APPLICATION NO: 23/00682/FUL/ADDINF

DESCRIPTION: Conversion of garage into habitable accommodation including alterations to raise roof height and erection of 1.5M fence to side and front boundary.

LOCATION: 64 Holland Pines Bracknell Berkshire

Block Plan

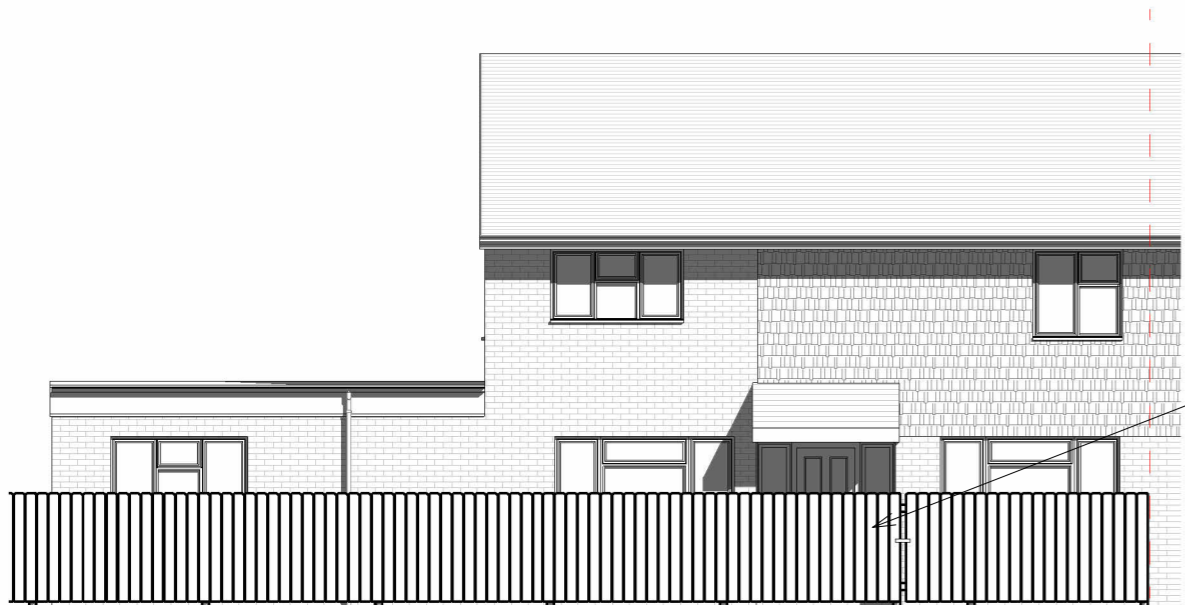
- 1 Please show the extent of the proposed new fence on the block plan and also please provide further details of the fence e.g. elevation plans. Do not submit the amended/additional information through the planning portal. Please EMail directly to myself.
